# A47 Blofield to North Burlingham

**Scheme Number: TR010040**

## **9.16 Request for a Non-Material Change to the Application**

The A47 Blofield to North Burlingham Dualling  
Development Consent Order 202[x]

Drawing Number	Rev
Highways England PIN	
HE551492-	P05
GTY-LLO-000-DR-BL-00005	
Location

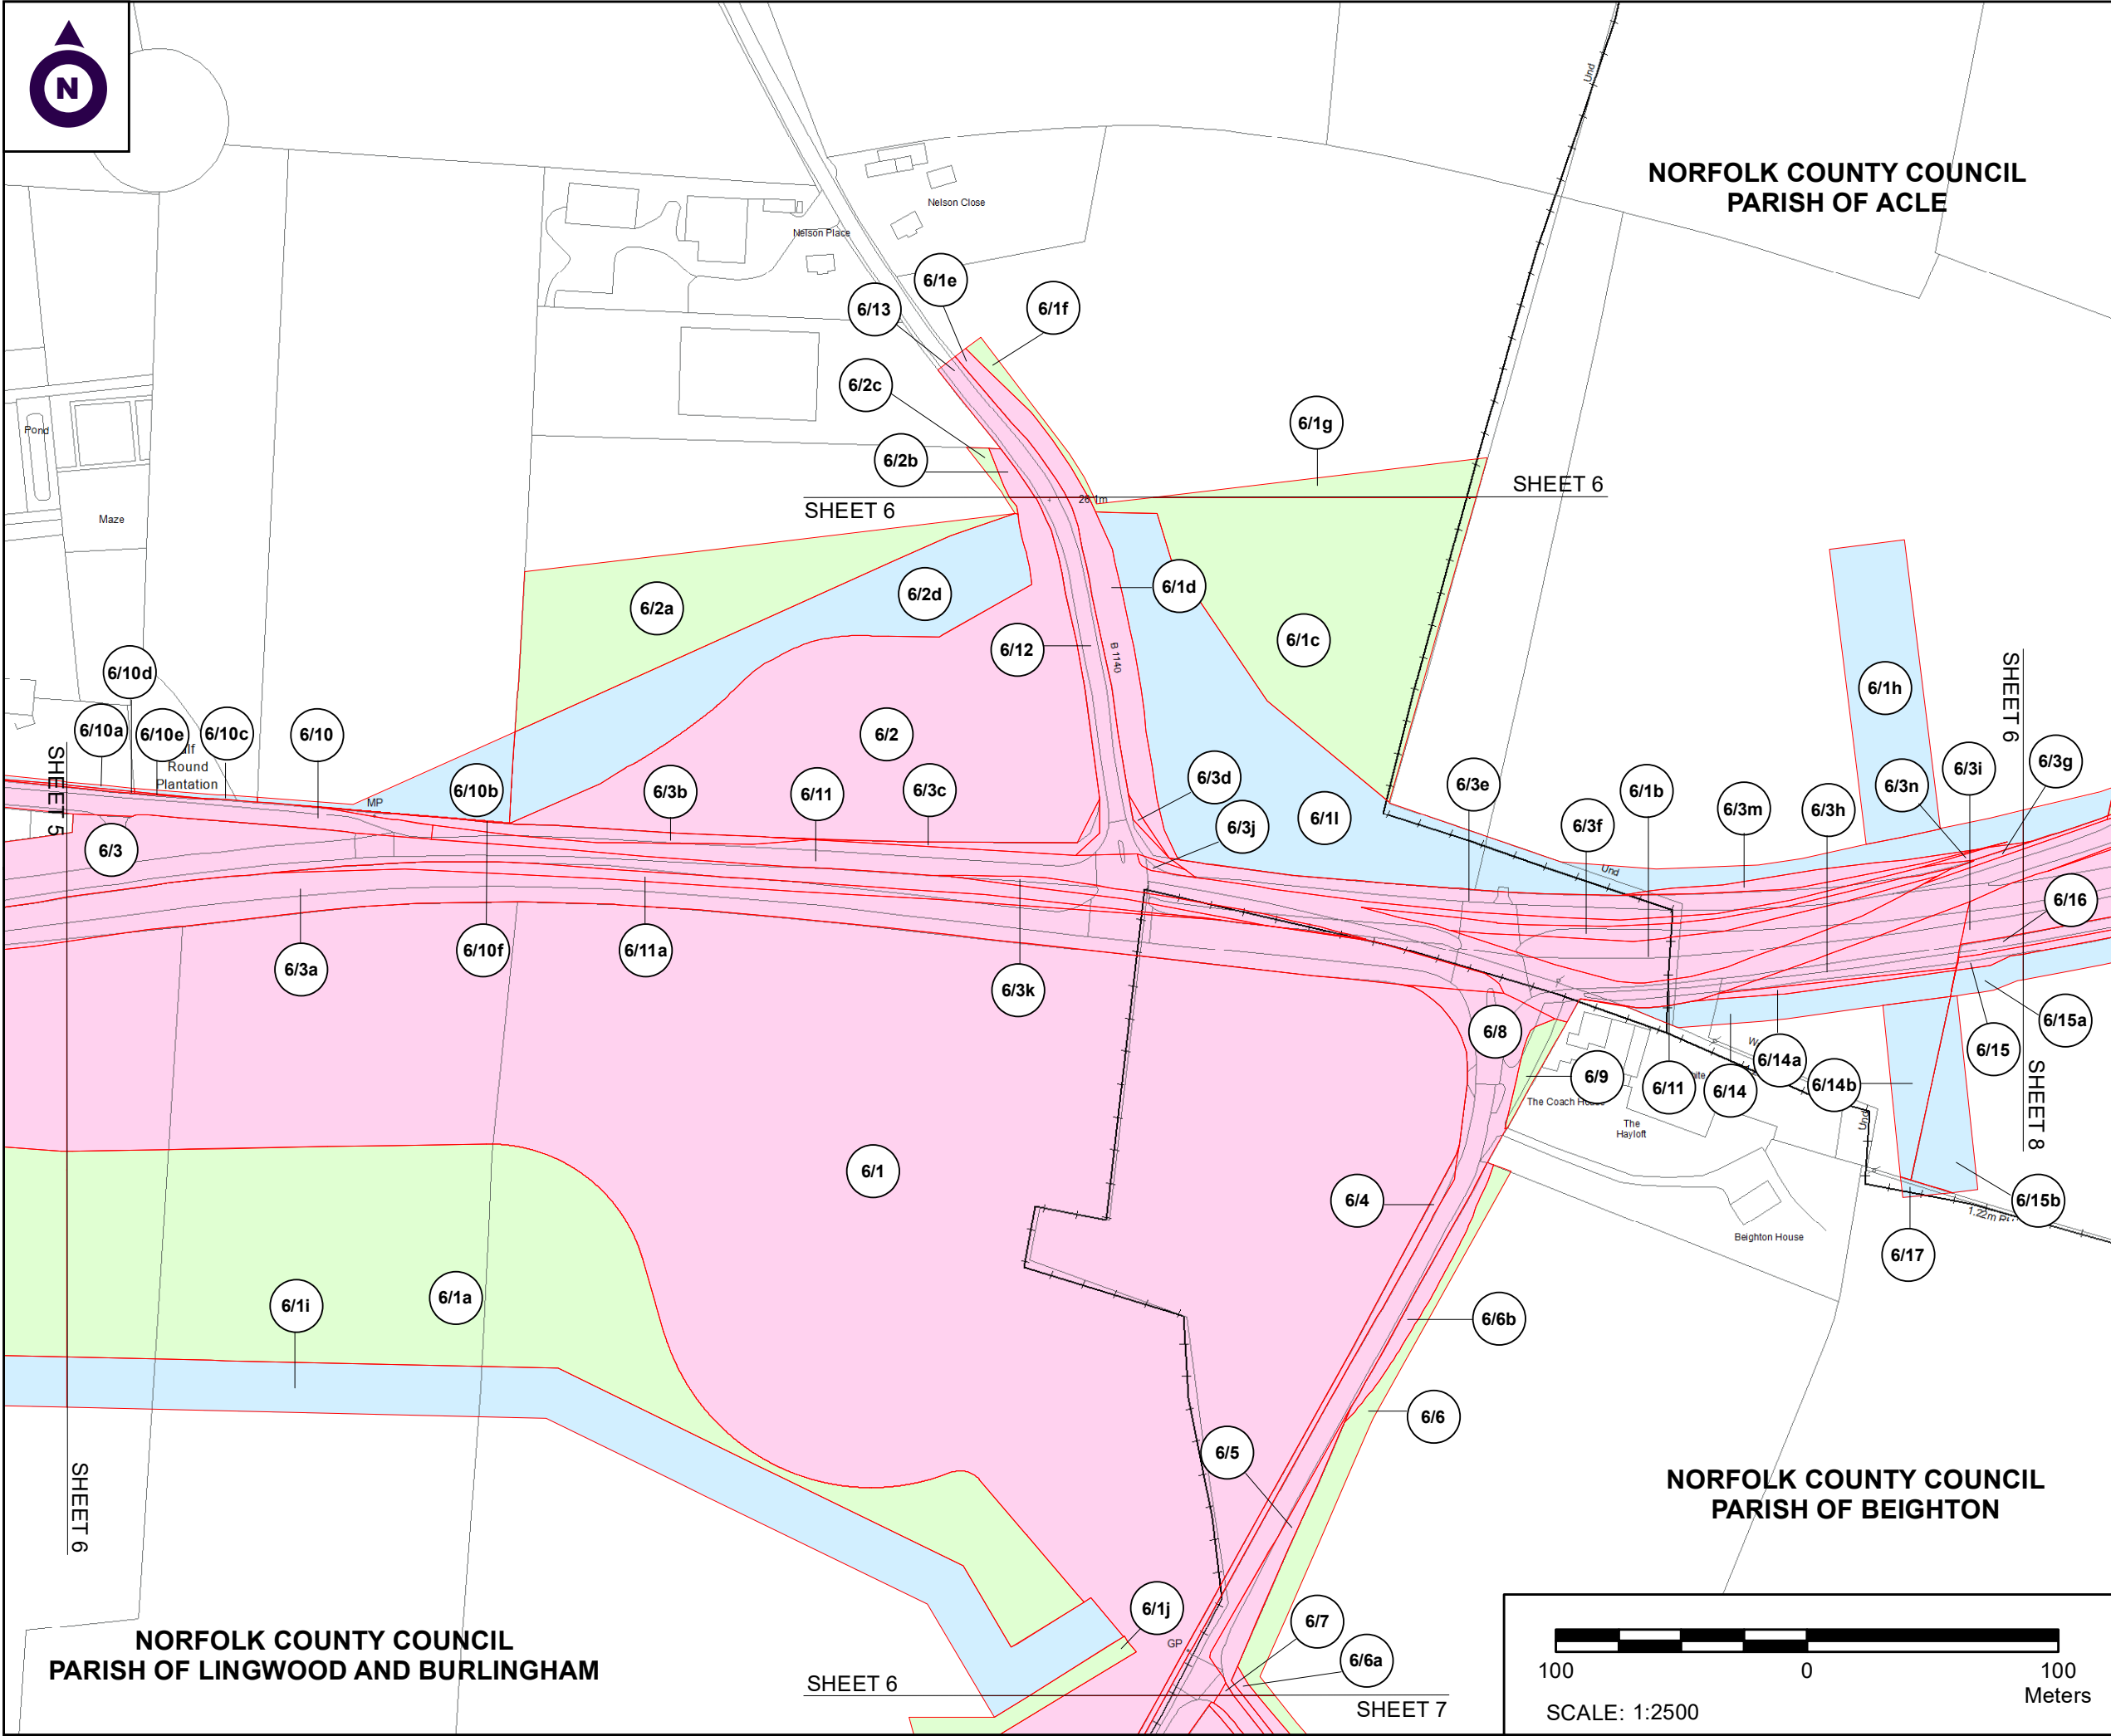
- 2.1.2 The Applicant has provided the above documentation to effect a proposed change relating to the re-provision of an existing block valve site (Existing Block Valve Site) belonging to Cadent Gas Limited (Cadent), which is situated adjacent to and to the south of the current A47. The Existing Block Valve Site is shown on sheet 5 of the Land Plans as plot 5/2 (**TR010040/APP/2.2 Rev 1** submitted at Deadline 4).

- 2.1.5 To allow the provision of the New Block Valve Site, a new permanent acquisition plot (plot 5/1e) has been added to the Land Plans (**TR010040/APP/2.2 Rev 1**) and the Book of Reference (**TR010040/APP/4.3 Rev 4**) on land for which temporary possession was previously sought. It is anticipated that this land would be vested in Cadent after completion of works. The extent of this plot reflects the limits of deviation for Work No.5, and a degree of uncertainty as to the precise location of the North-South Gas Main (historical records as to the location of the apparatus of statutory undertakers is generally imprecise).

- 2.1.6 In addition to acquiring the New Block Valve Site, it will be necessary to provide a replacement access to the New Block Valve Site (Replacement Access). The Existing Block Valve Site is accessed directly from the existing A47, however this will not be possible for the New Block Valve Site. It is therefore proposed to provide a new access track, leading south from the access track included in Work No. 23. New rights will be required for the new access track between Work No.23 and the Diverted Gas Main, and this has necessitated the creation of a new rights plot (plot 5/1b). Although the description of Work No.5 does not need to change, the limits of deviation for Work No.5, shown on sheet 5 of the Works Plans (**TR010040/APP/2.3 Rev 1**) need to be amended to take into account the land on which the Replacement Access is to be provided.

- 2.1.7 Finally, the new access track will need to provide sufficient room for van and trailer to turn around. As a result it is necessary for the access track to continue over the line of Work No.5 as far as the Order Limits. This land will remain "blue" land (limited to the acquisition of rights), however in addition to the rights to install and keep the Diverted Gas Main in the land, access rights will also be required over the land. As a result a new rights plot (plot 5/1g) has been added to the Book of Reference (**TR010040/APP/4.3 Rev 4**) and the Land Plans (**TR010040/APP/2.2 Rev 1**).
